Nunnerley House Farm Leaveslake Drove West Pinchbeck Spalding PE11 3QJ

H14-1288-25

03/02/2026

After reviewing the proposal in full, I recommend that the application be refused on the basis of Policy 23 of the South East Lincolnshire Local Plan (2011–2036): The Reuse of Buildings in the Countryside for Residential Use. This policy establishes five criteria that should be met for the residential conversion of an existing building to be supported by the Local Planning Authority.

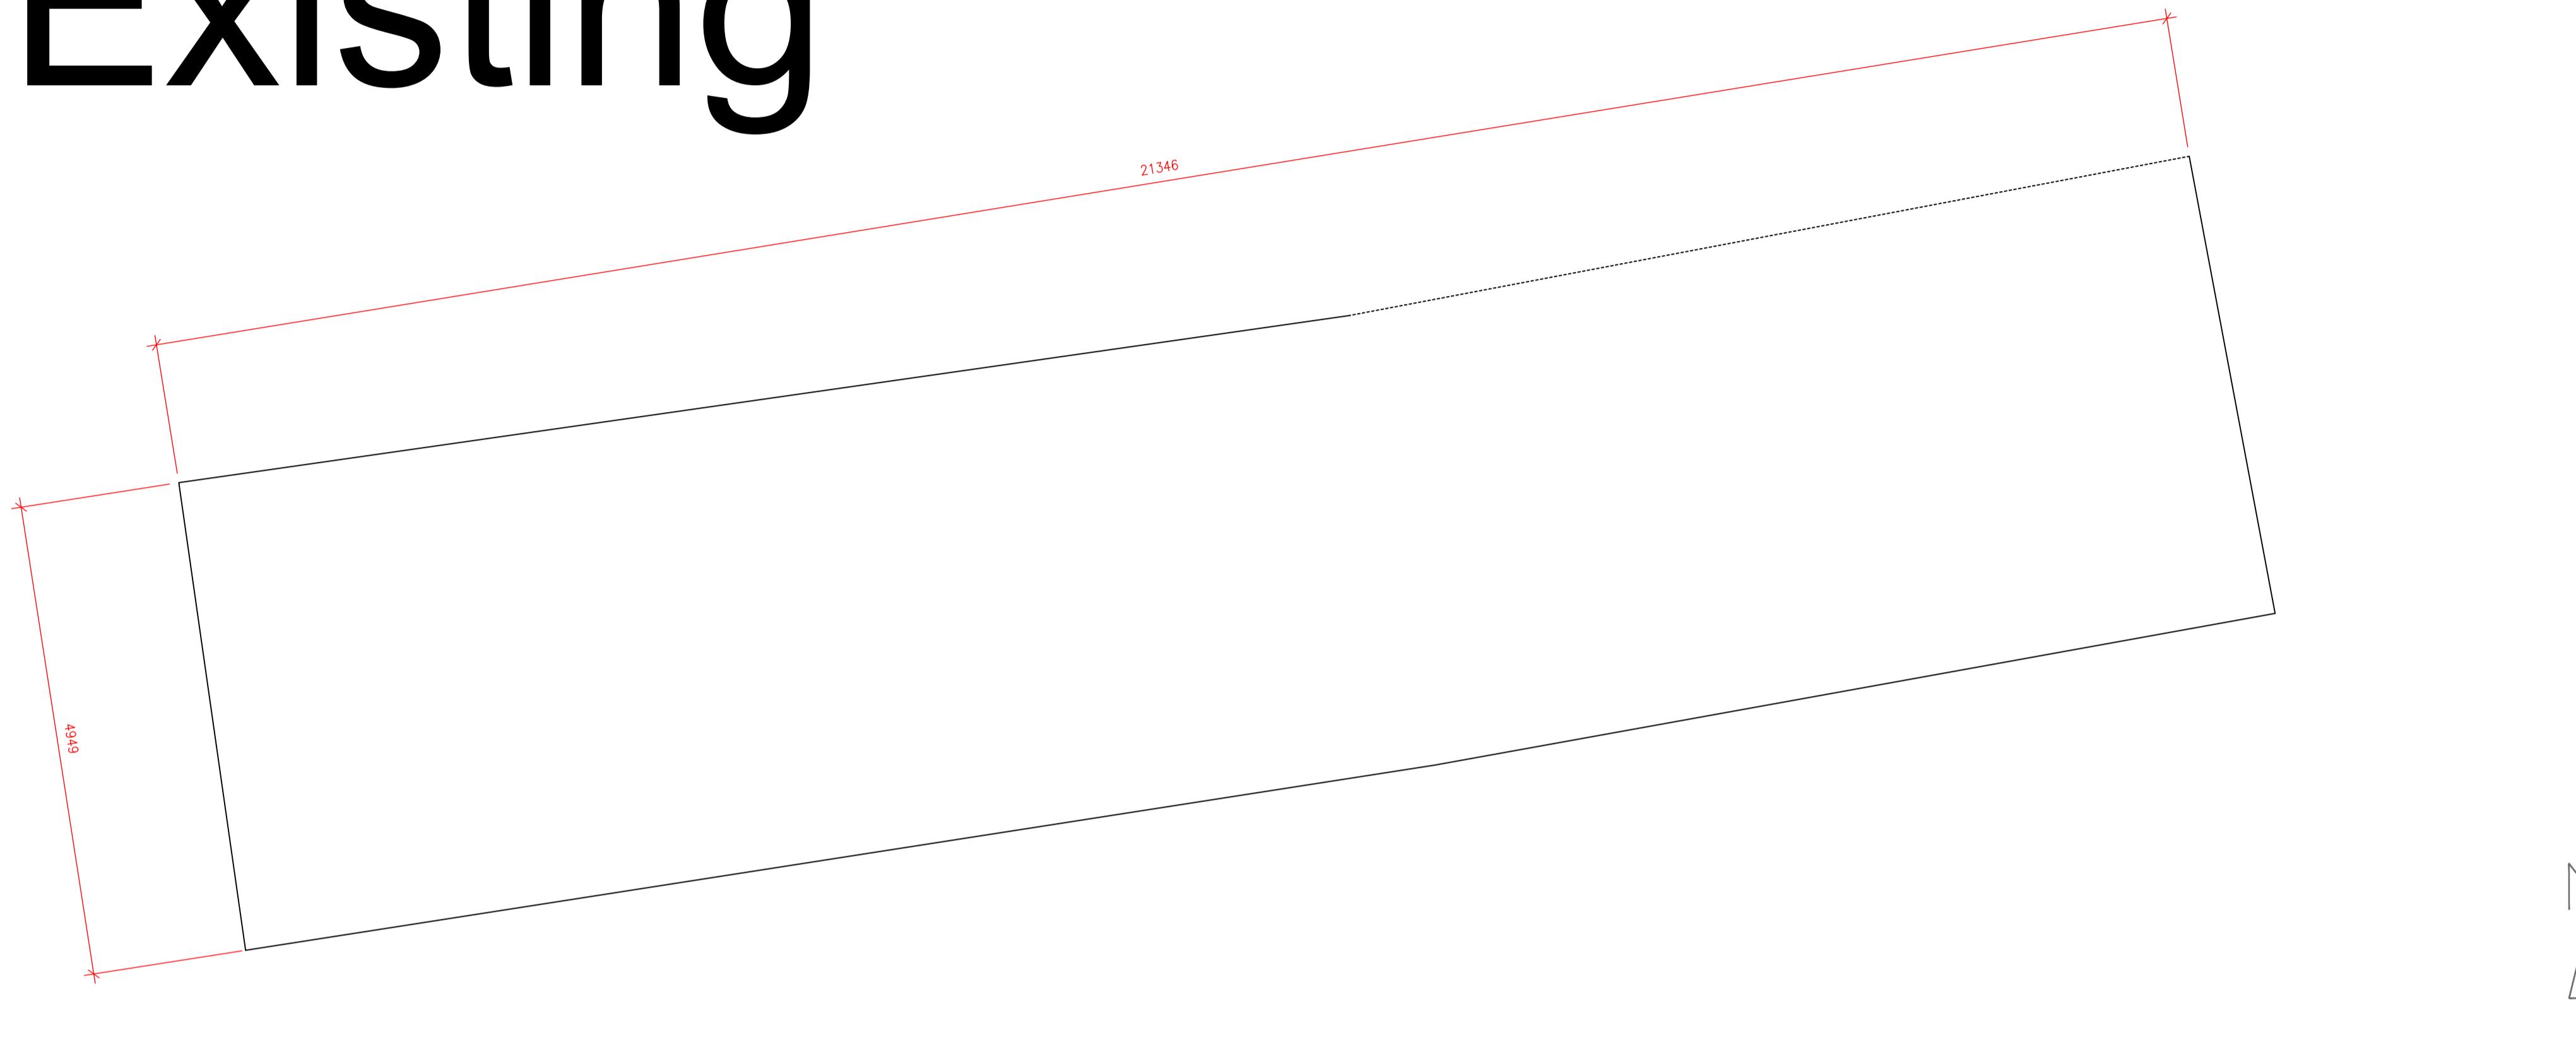
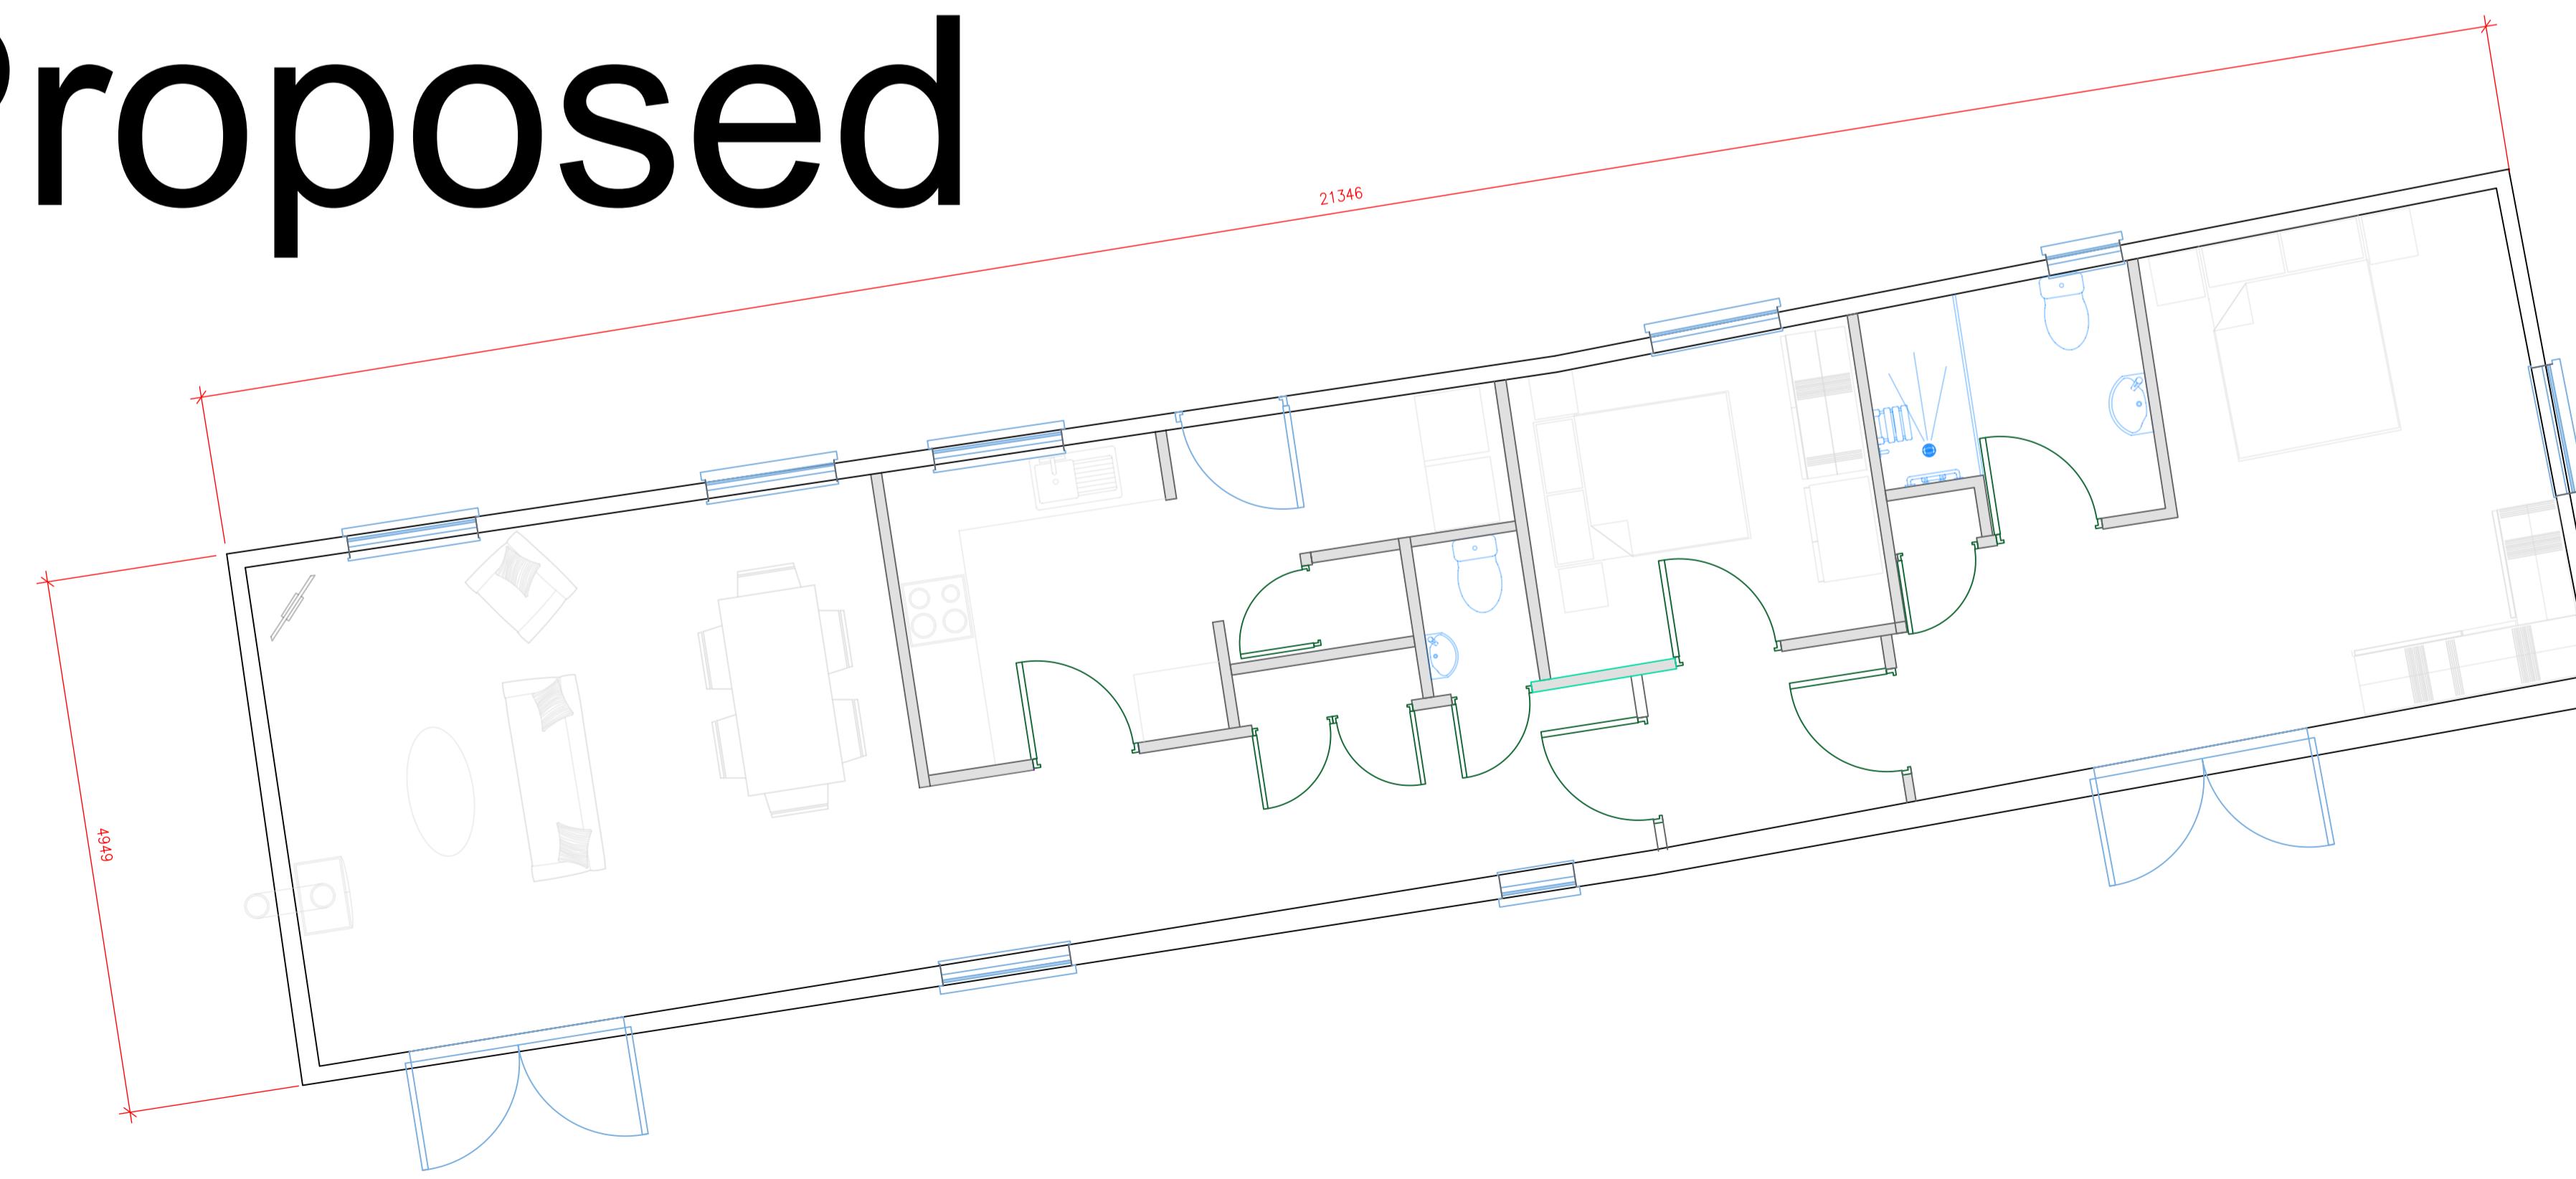
The barn identified for conversion would require extensive works, including the installation of an entirely new roof, the complete enclosure of the northern elevation, external cladding, and the insertion of multiple new openings across the remaining elevations. In addition, the submitted information indicates that a number of structural timbers are either damaged or decayed and will need repair or replacement, although the exact number for this intervention is not supplied.
